Transport

**EXHIBITION OF ENVIRONMENTAL ASSESSMENT FOR WEST CIRCULAR QUAY
PUBLIC DOMAIN UPGRADE WORKS (MP10_0104)**

David Hartmann
A/Senior Manager
Centre for Transport Planning

Roof Garden Walk

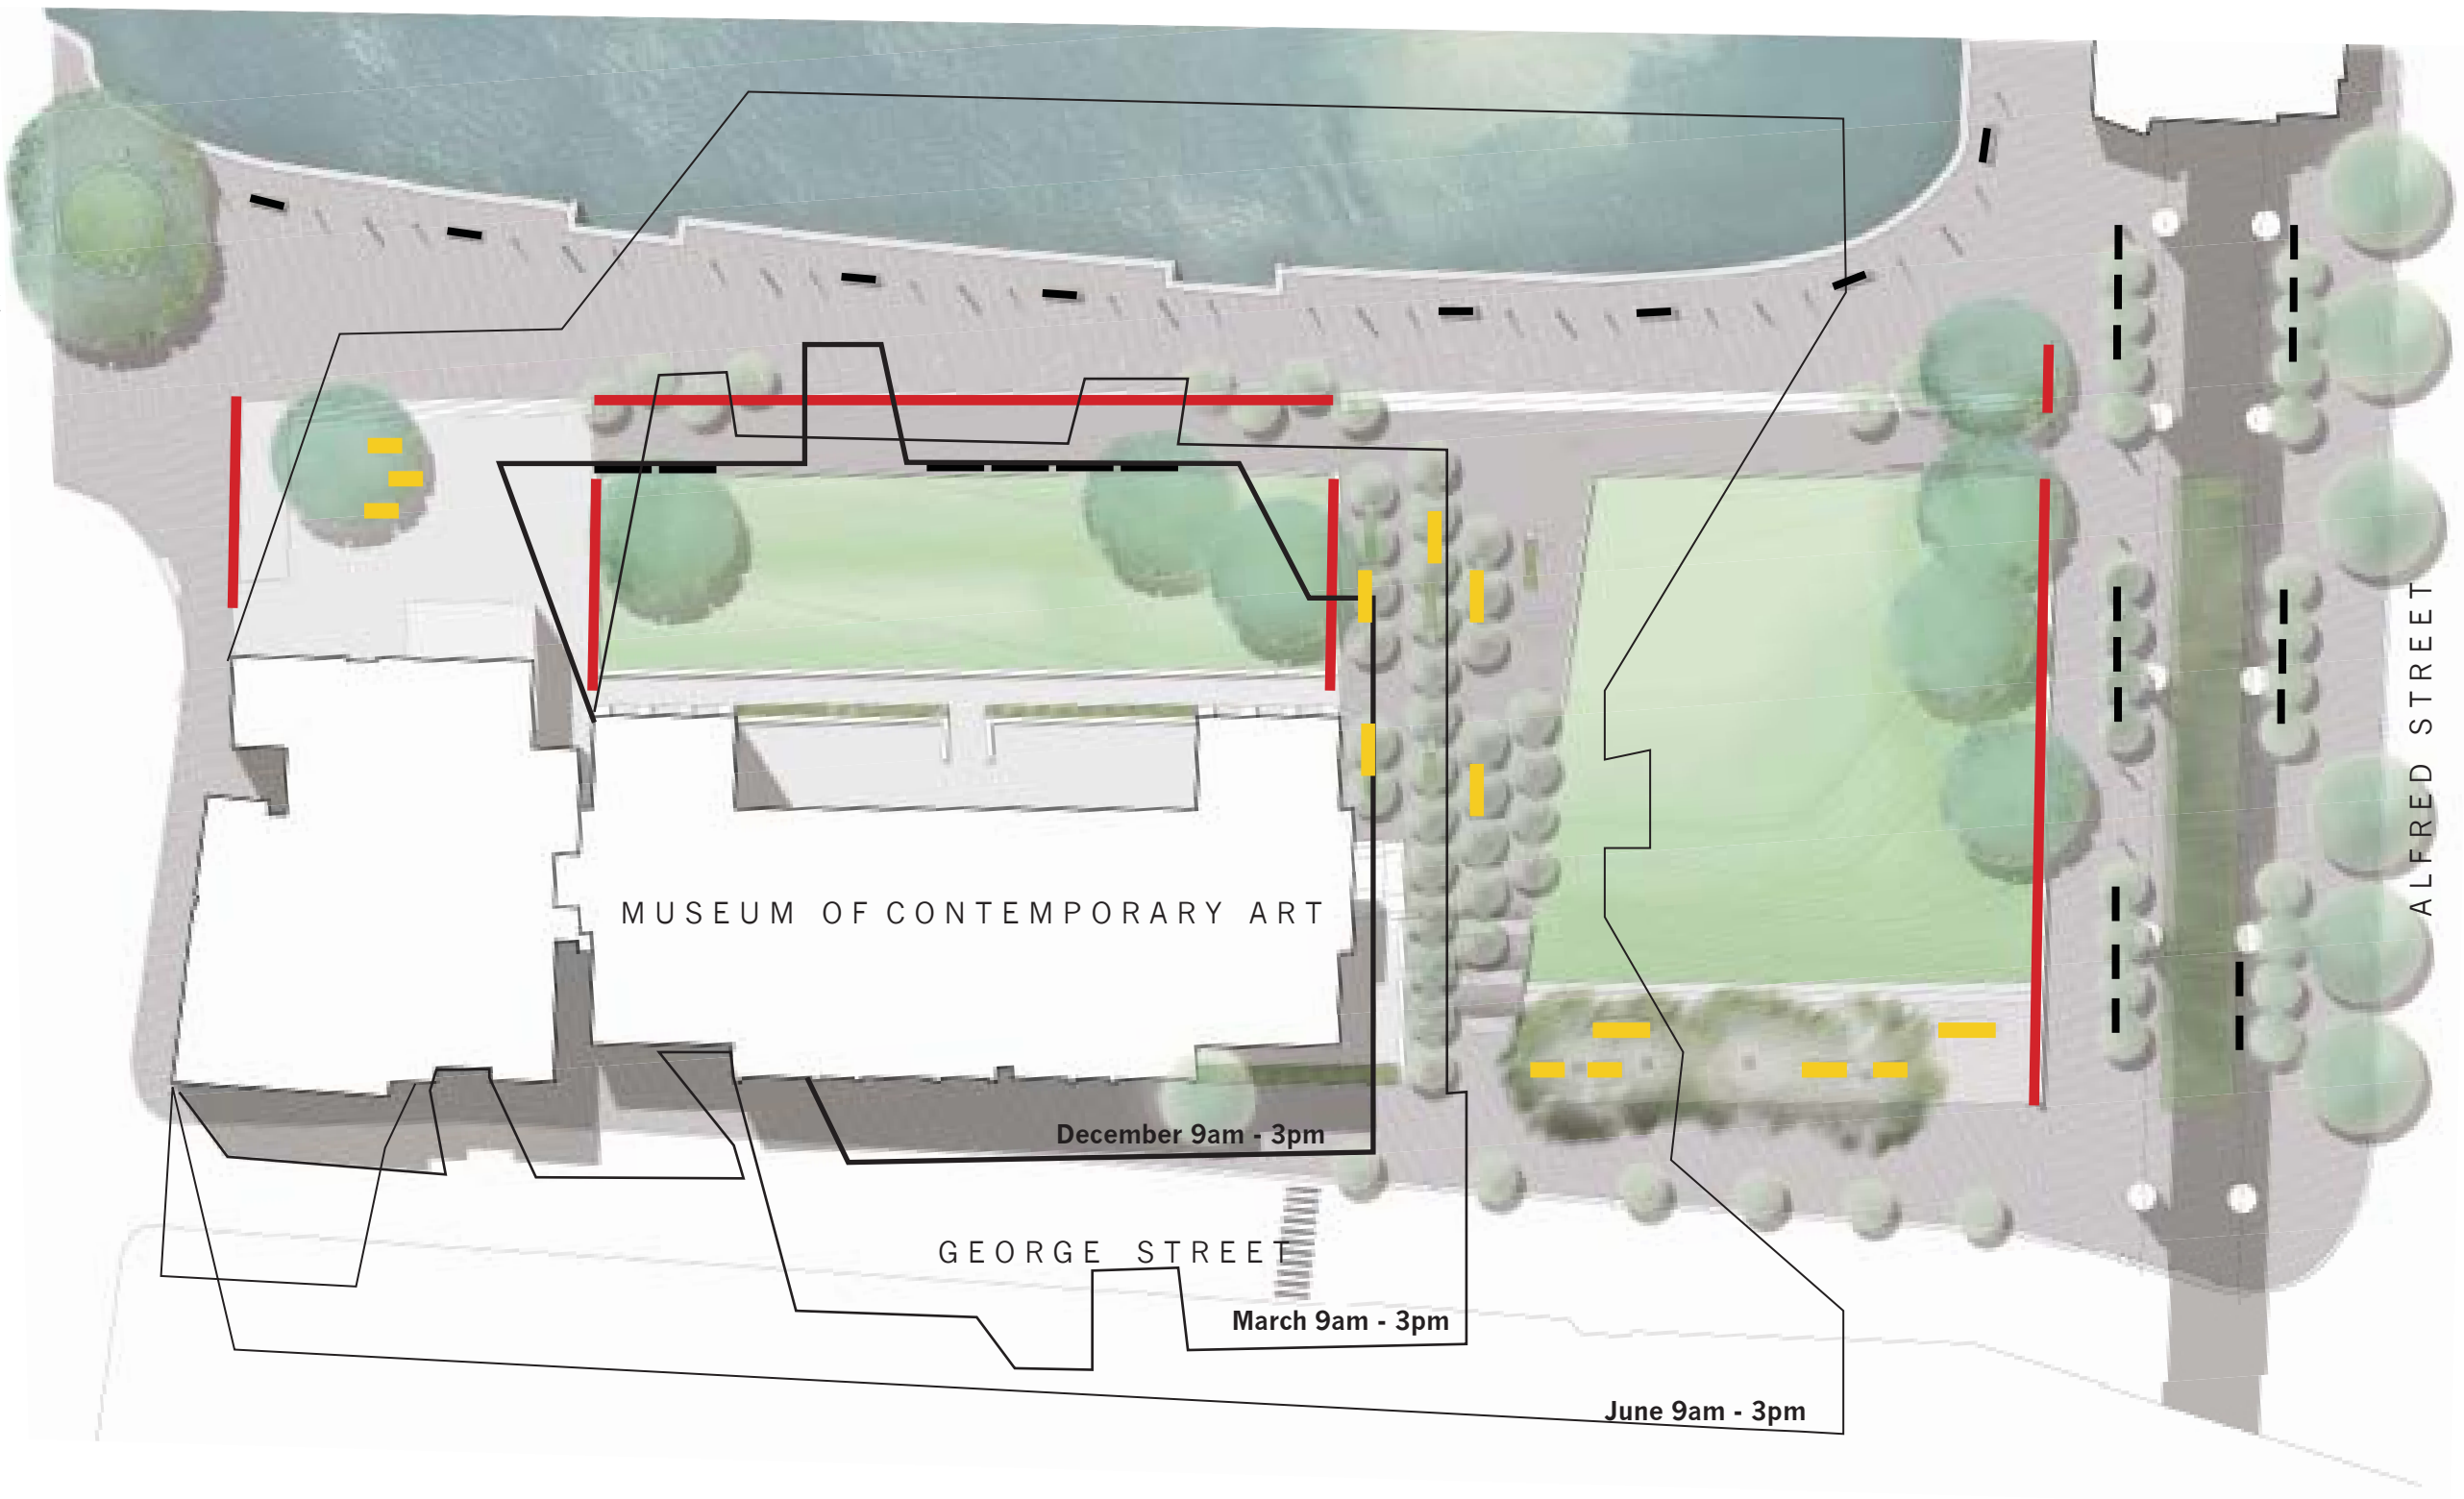
As part of the Metropolitan Transport Plan, the Government has committed to extending the existing light rail system from Haymarket to Circular Quay. TNSW is currently assessing potential alignments for a CBD light rail extension. In regards to the proposed 'green roof', TNSW requests that a minimum height clearance of 4.5 metres be maintained under the Cahill Expressway to allow for any possible future light rail system.
